Recommendation Report for Planning Permission for Works or Extension to a Dwelling

REF NO: M/87/15/HH

LOCATION: 6 Templesheen Road
Elmer
Middleton-on-Sea

PROPOSAL: First floor rear extension. Resubmission of M/65/15/HH

Scales: 1:100 1:200 **No:** 1769/01/02/A

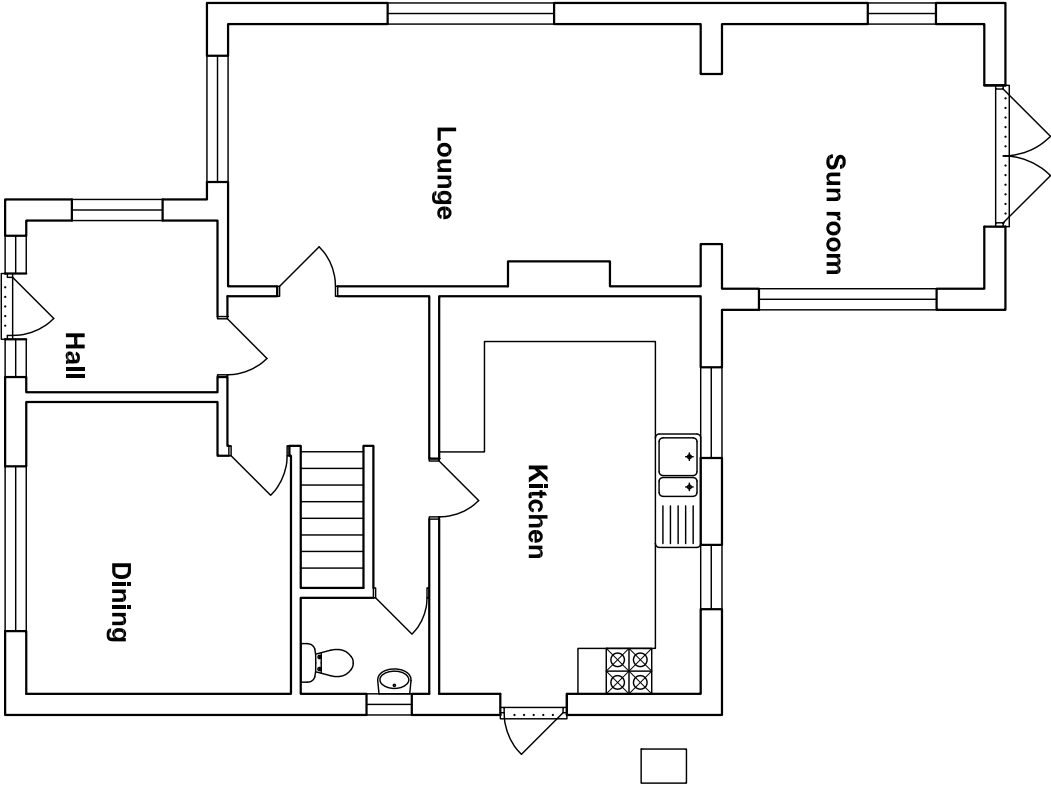
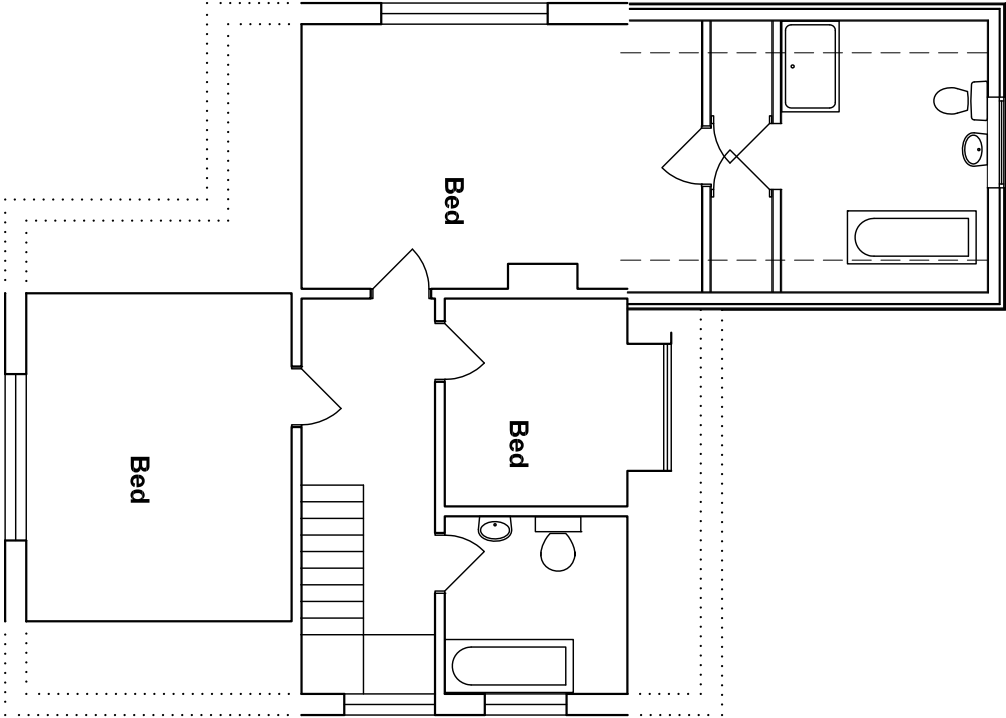
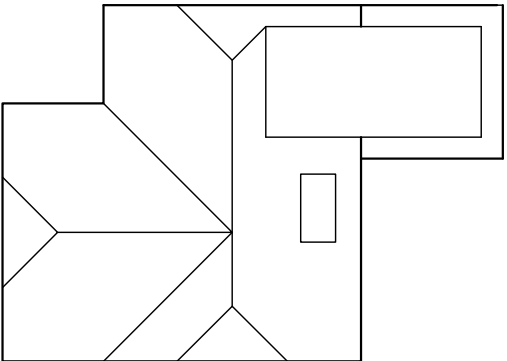
It is proposed to erect of first floor rear extension to this dwelling. The extension is to be above an existing single storey flat roofed rear extension on the rear west side of the dwelling.

The extension would be of the same width and depth as the existing rear extension and would measure 3.8m in depth 4m in width. Depth of the extension, due to the rear roof plane of the existing dwelling would be 5.4m at eaves level. No side windows are proposed and there is to be a

single rear window. The additional accommodation is to form a bathroom. Materials are proposed to match those of the existing dwelling, in that the first floor extension will be white painted. A mock pitch with flat roof behind has been proposed.

The proposed extension is set away from the west boundary and the adjoining dwelling. There is little if any impact on light and the extension is not unduly dominant in outlook. The absence of side windows means that there is no privacy loss and the nature of the accommodation (bathroom) means that it is unlikely that the rear window serving that room will give rise to overlooking or privacy loss.

This application seeks planning permission for the development outlined in this report and will result in change to the appearance of this dwelling. The revised design introduces a more acceptable visual appearance as a consequence of the removal of the poor transition between ground and first floor and the provision of a mock pitch. The extension is now more consistent with the appearance of the existing dwelling and is considered to be visually acceptable in terms of the appearance of the existing dwelling and the visual amenity of occupiers of surrounding dwellings.

Drawing Number 1769/01/02/A - Plans & Elevations proposed - Dated June 2015

- 4 No additional windows (other than those shown on the plans hereby approved) shall be constructed in the south west side or north east side elevations of the extension hereby permitted without the prior permission of the Local Planning Authority on an application in that behalf.
